RE: (24 0277) development address: 4, Springs Road, Longridge, PR3 3TE.

I have received a planning notification for the above property. As a [REDACTED] I would like to put forward the following concerns (objections) to the application:

PROPOSED FLOOR PLANS & SECTION

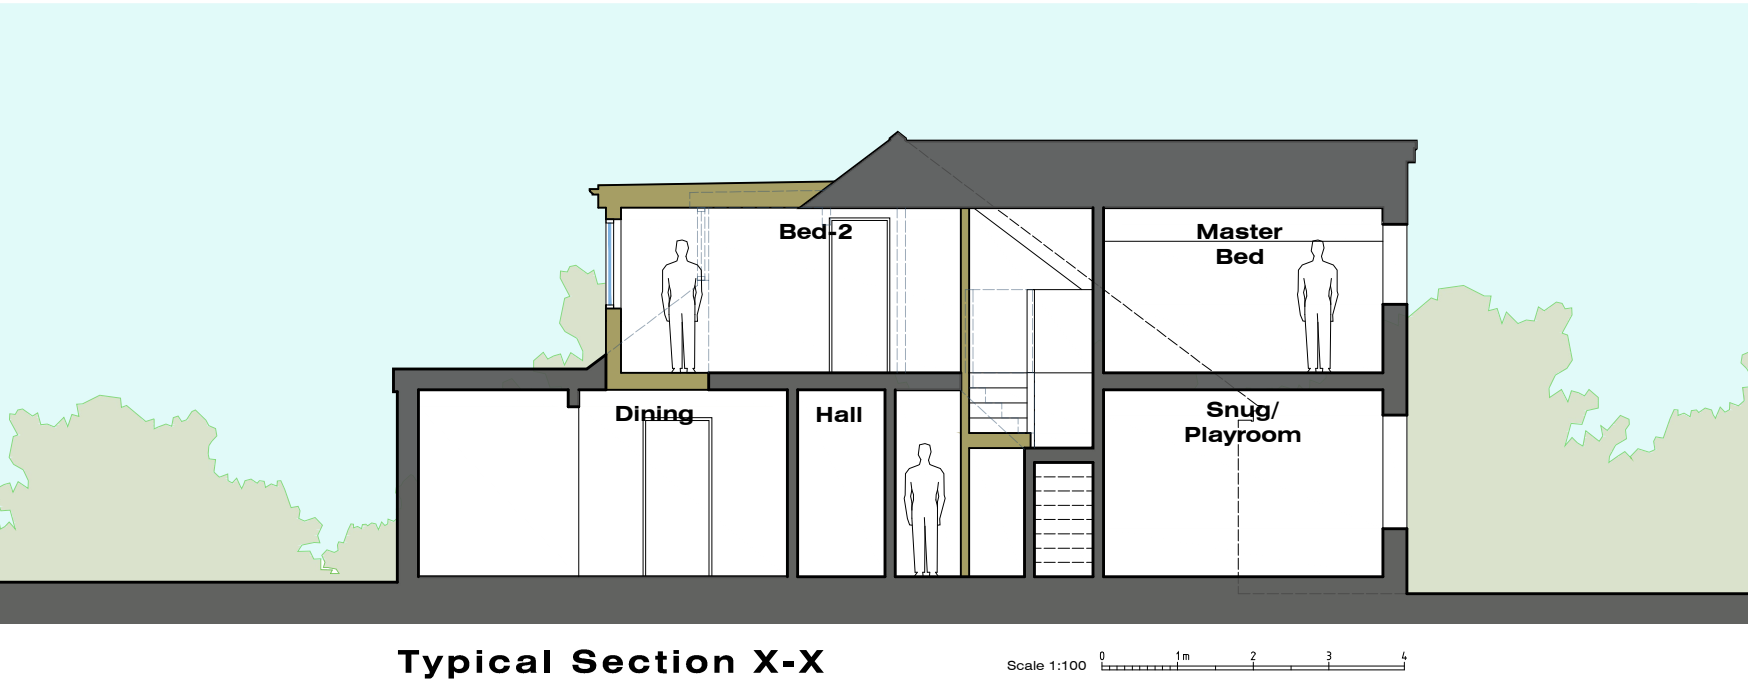
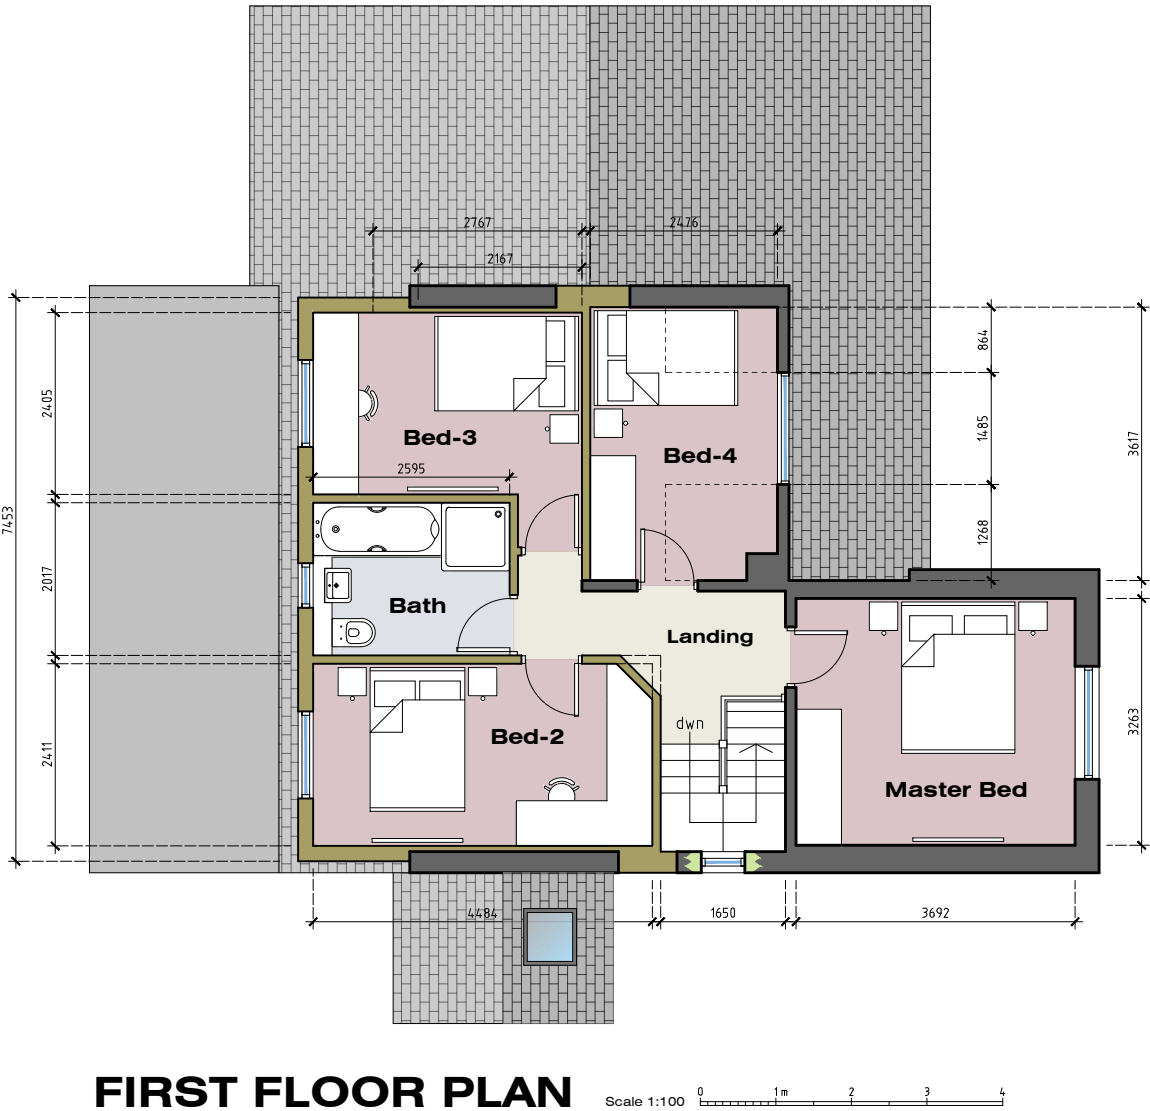
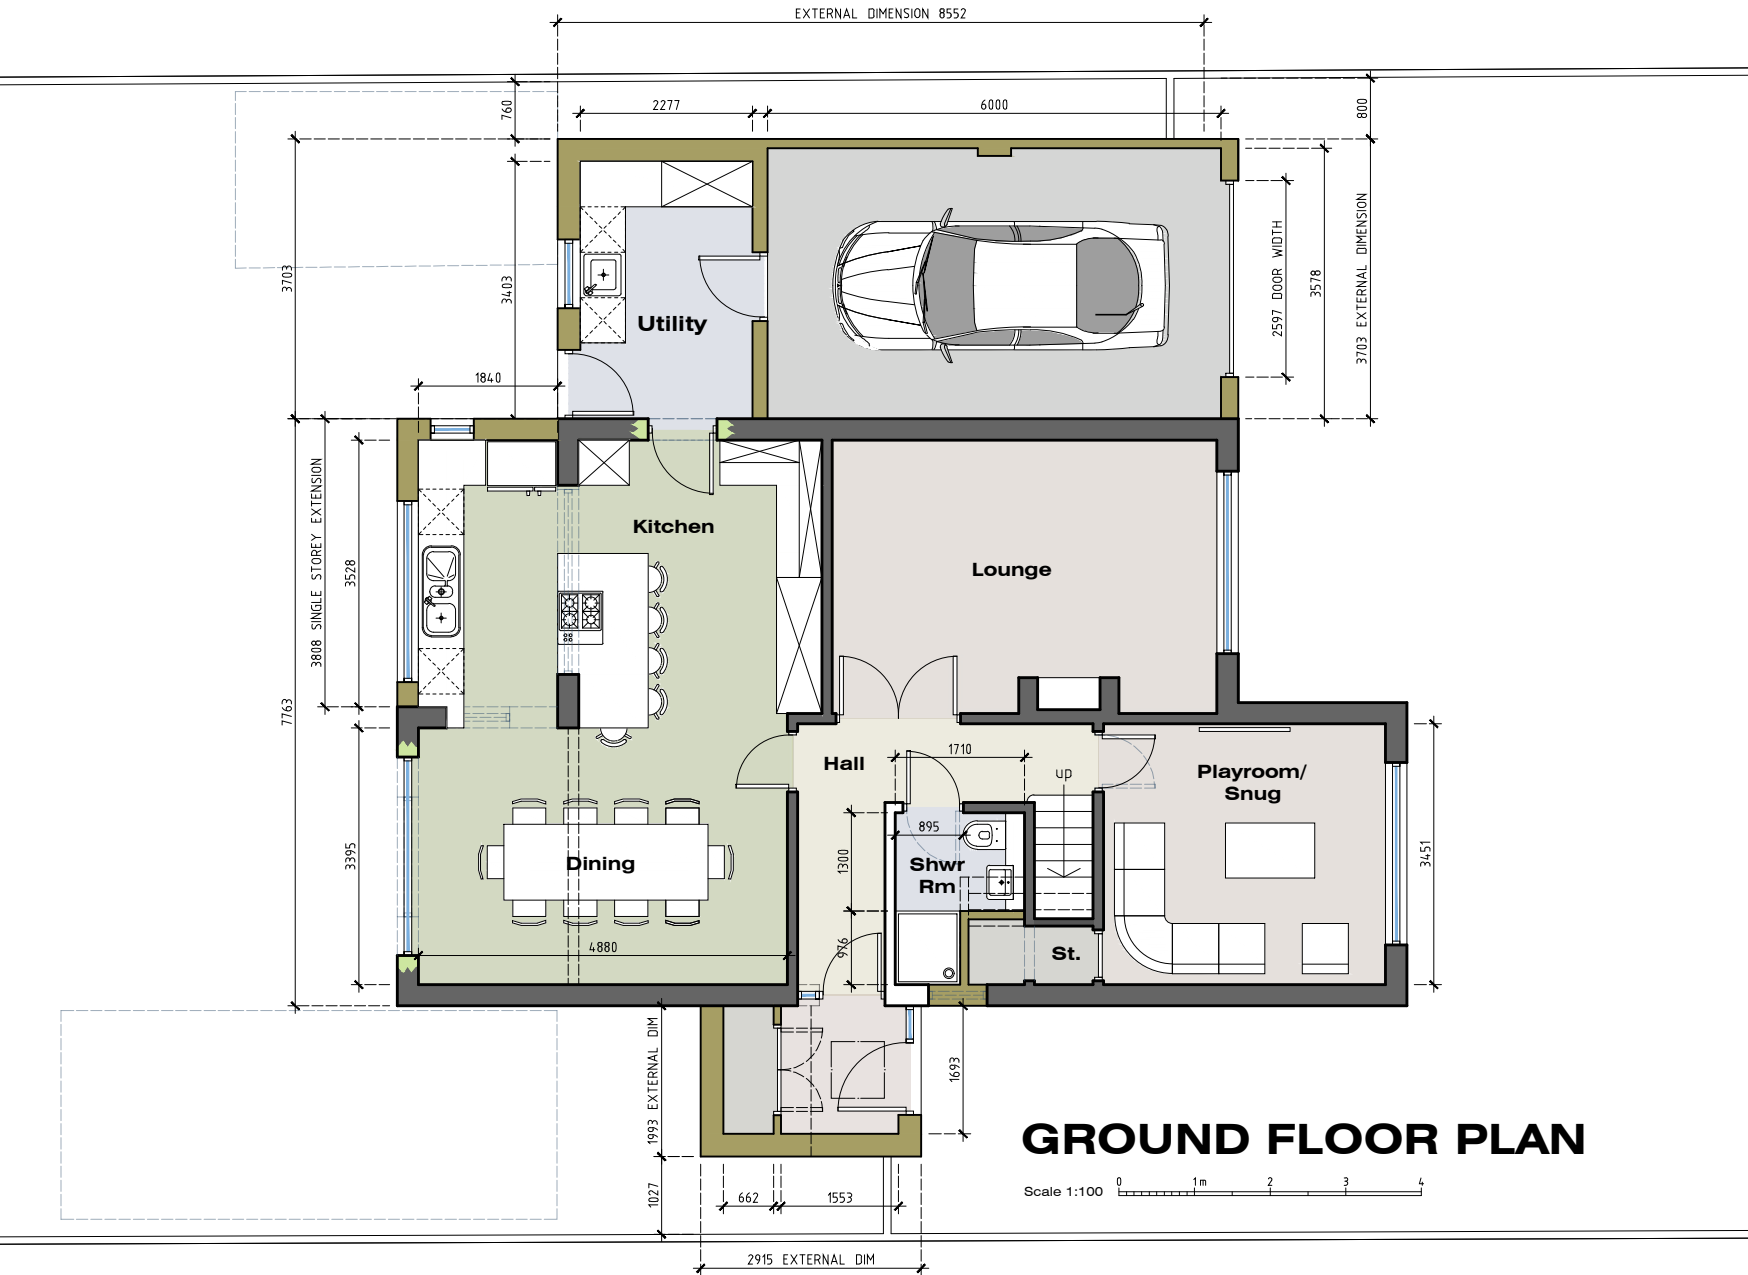
1. The proposed extension will extend the property's footprint that may result in the reduction of natural light [REDACTED] In context [REDACTED]
[REDACTED]

4. The property has previously been increased in size, with the latest application significantly changing the original floor plan and character.

PROPOSED SITE PLAN

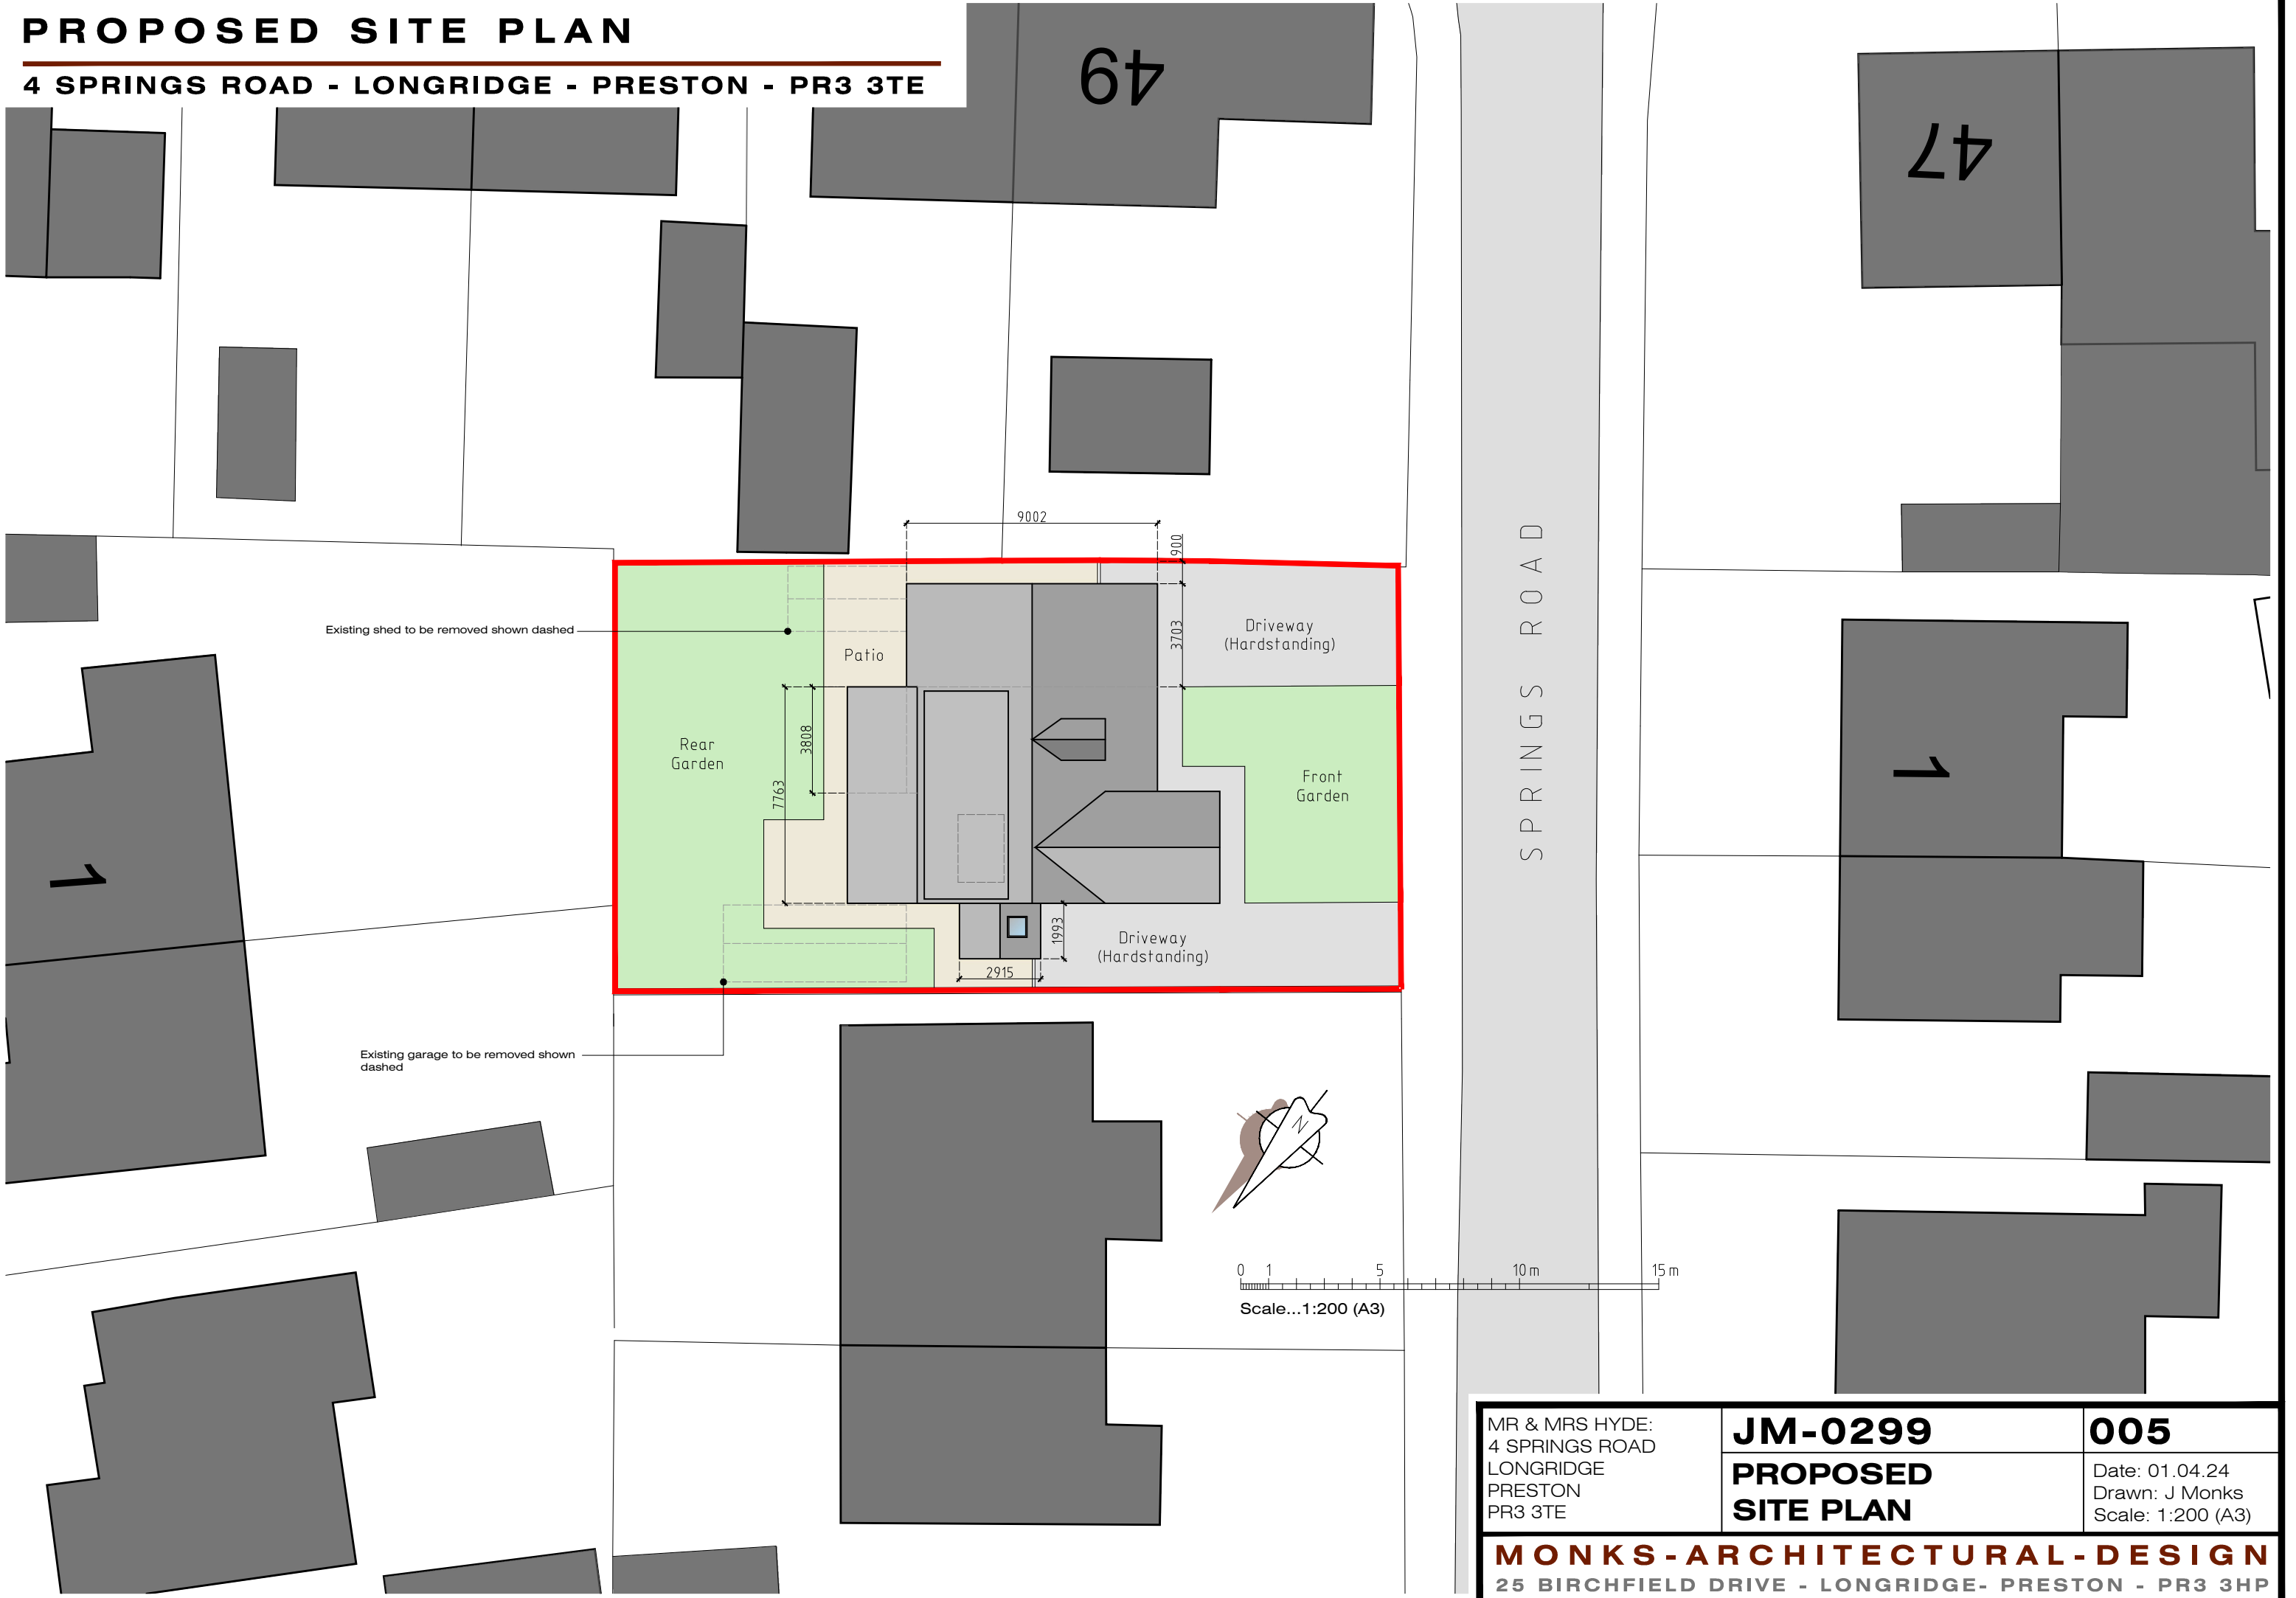
2. The proposed extension will reduce the space between properties. This would appear out of character, within the immediate neighbourhood.

5. At present the property at 4, Springs Road has an outbuilding that constitutes [REDACTED] The plan appears to omit whether this will still be in place and if not the arrangements/liability for the effective restoration.
